Letter of Intent

Phil and Ivonne Strevett are seeking approval of a Site Development Plan to convert two of our existing buildings into a dog breeding/training facility which will include one building for 20 indoor/outdoor kennels and another for 4 indoor/outdoor whelping kennels as well as administrative relief for a 20% reduction of the 200 ft property setback requirement

Cover page/Letter of Intent

Whelping Kennel

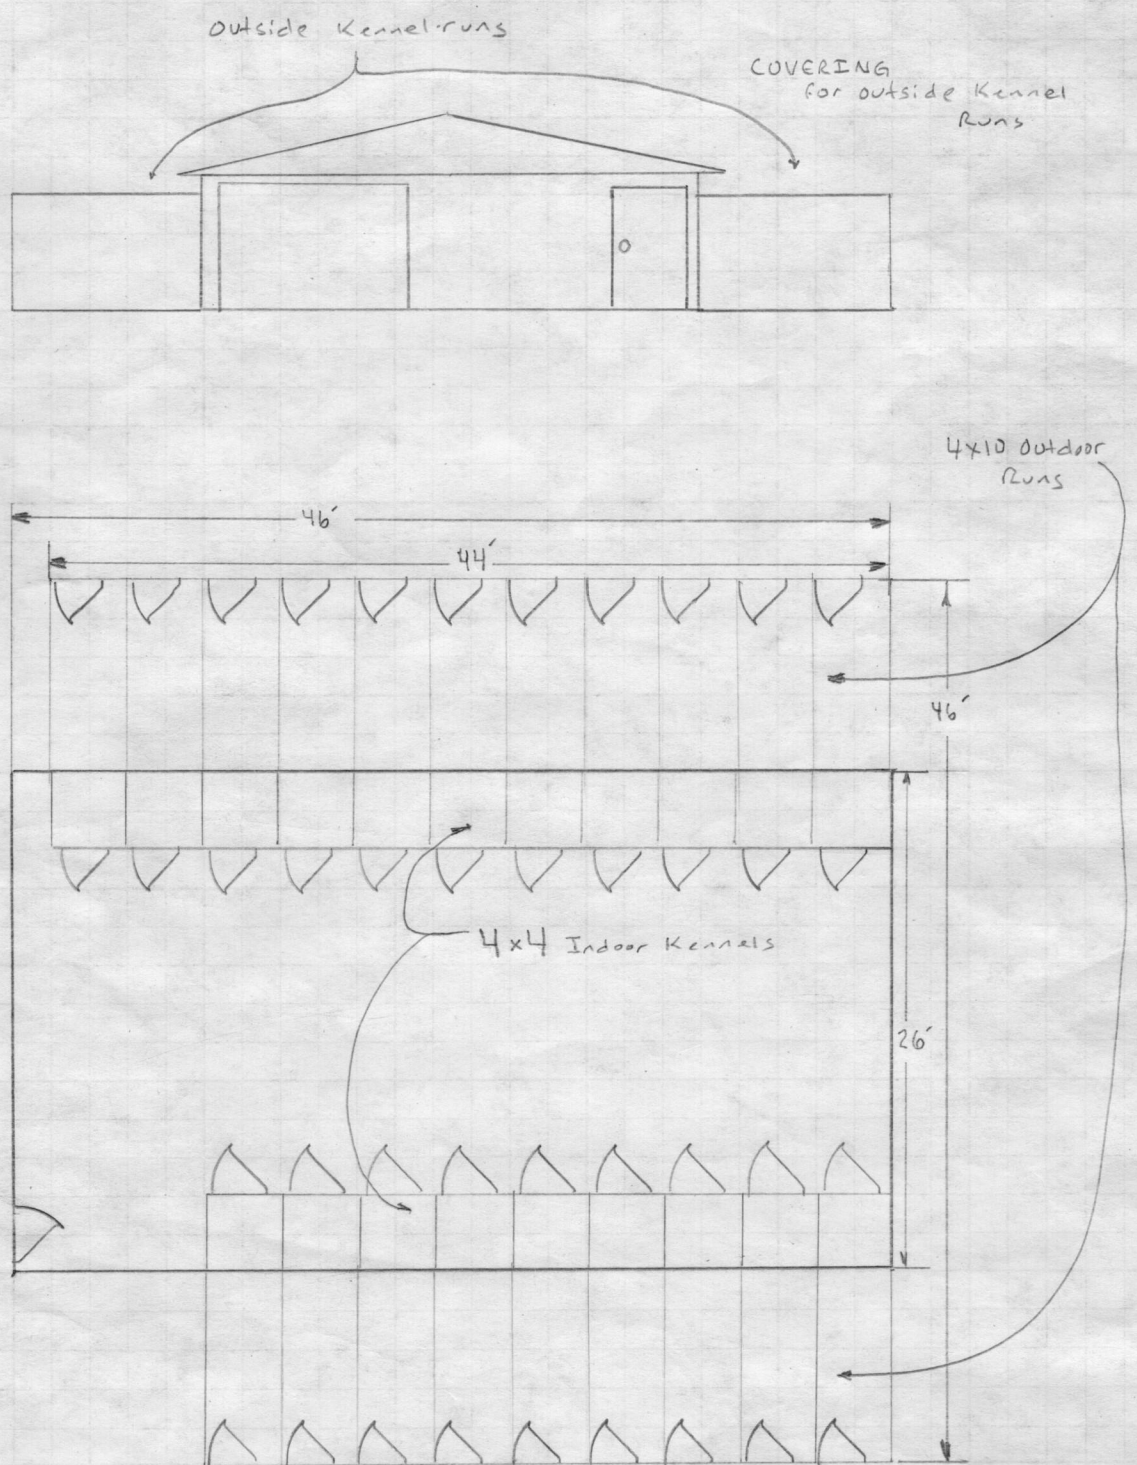
Please verify that you are requesting administrative relief. This is a separate application with a fee of \$587. If you can move the yelping kennel to 200 feet then that application will not be needed.
